## EXPERT ADVICE - VEP WESTERN EMPLACEMENT

ATTENTION:	Mr Steve O'Donoghue, NSW Dept of Planning Infrastructure and Environment	
FROM:	Hugh Middlemis, Principal Groundwater Engineer, HydroGeoLogic	
REFERENCES:	12 March 2020	DPIE ref: Vickery Extension Project Groundwater Assessment
	HGL job#: 61.073	
SUBJECT:	Vickery Extension Project groundwater assessment - Western Emplacement

Please refer to Figure 3 for the alluvial boundaries and the Western Emplacement.

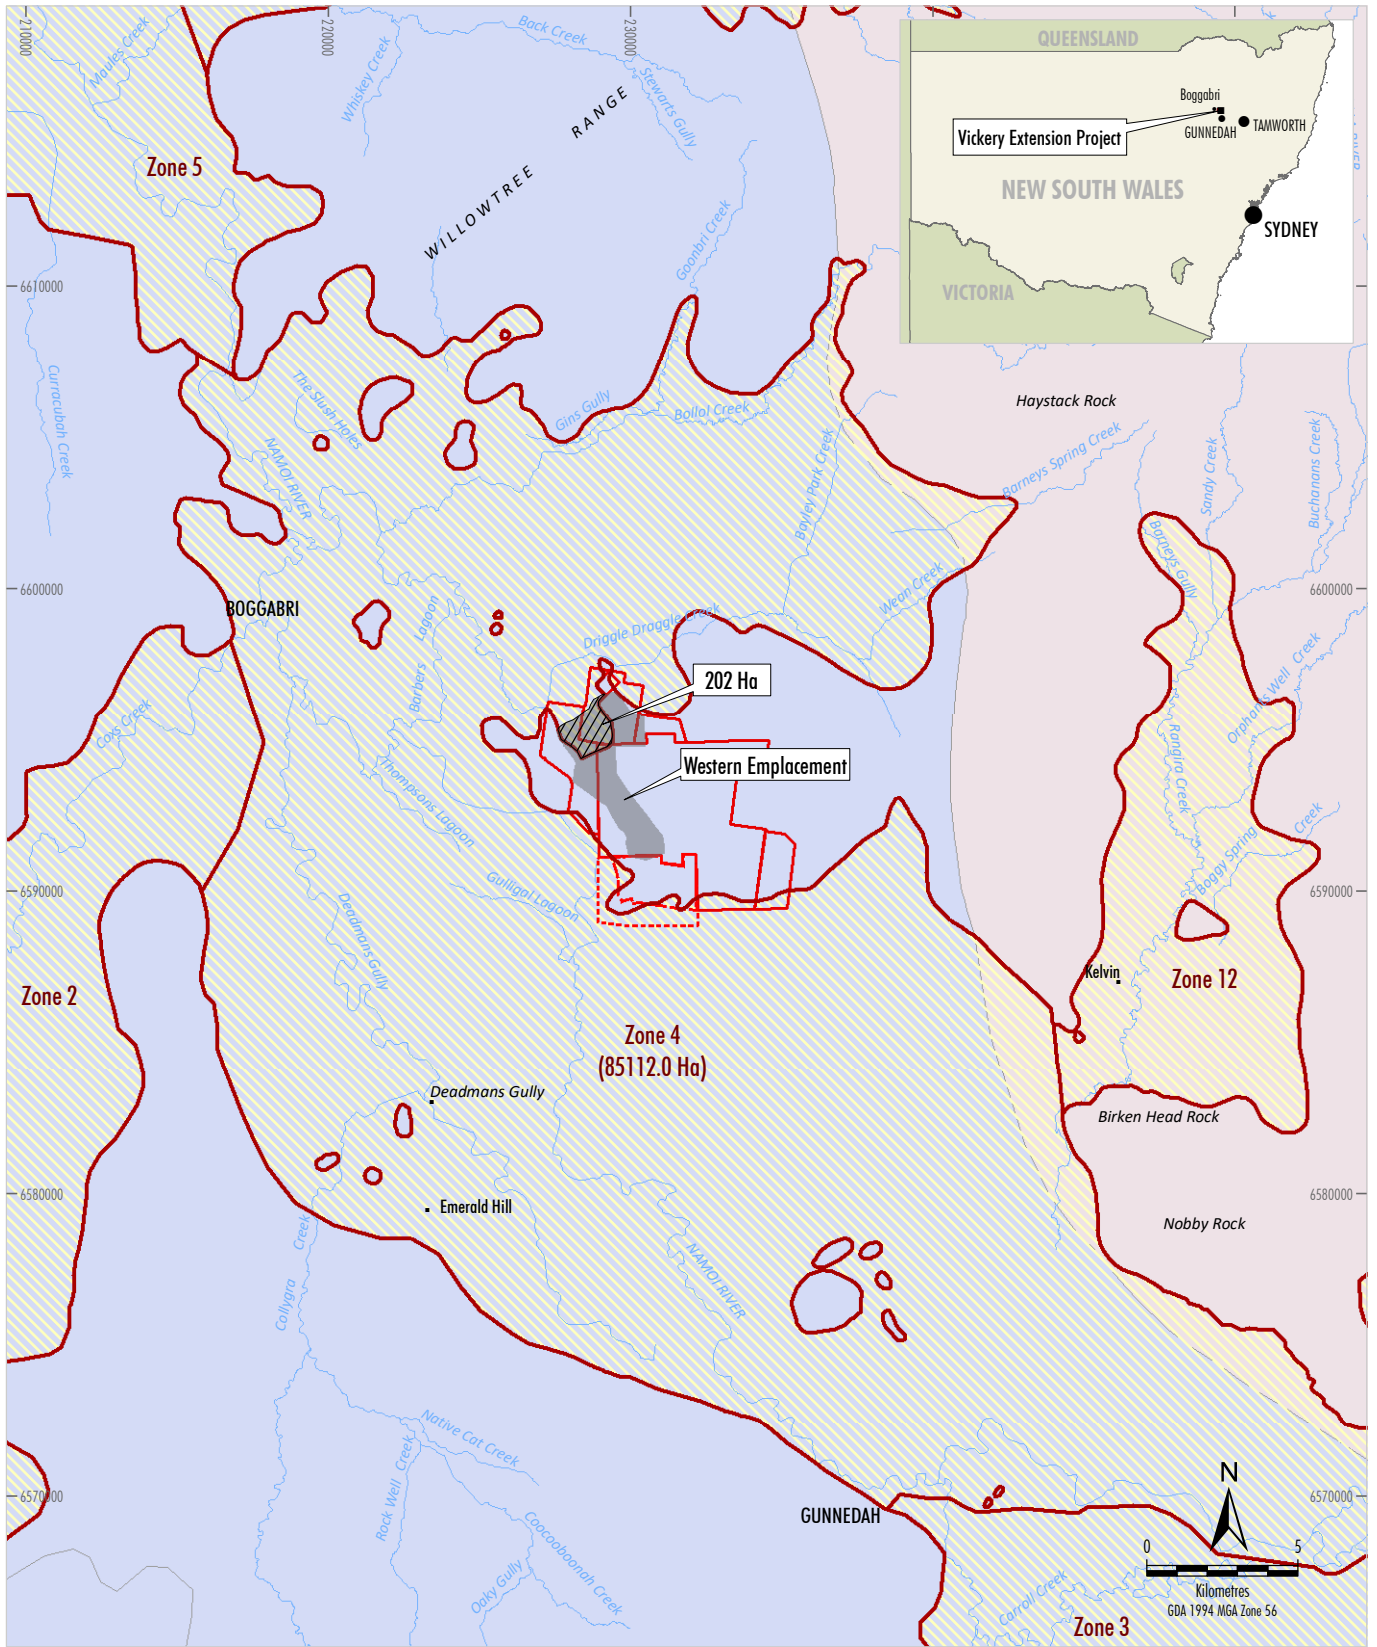
- assuming that closure will involve a final void at the south-eastern corner of the VEP, the modelled water table at 100 years after the end of mining shows that the long term final void groundwater 'capture zone' extends across the Western Emplacement over the alluvium embayment (VEP Submissions Report, August 2019, Figure 8b); this means that seepage from the Western Emplacement would indeed flow towards the final void sink rather than towards the alluvium.

- the embayment alluvium underlying the Western Emplacement has already been impacted by the existing Canyon Coal Mine final void, as Whitehaven Coal point out, but the potential compaction impacts on the 'clay-dominated' (compressible) alluvium has not been assessed specifically.
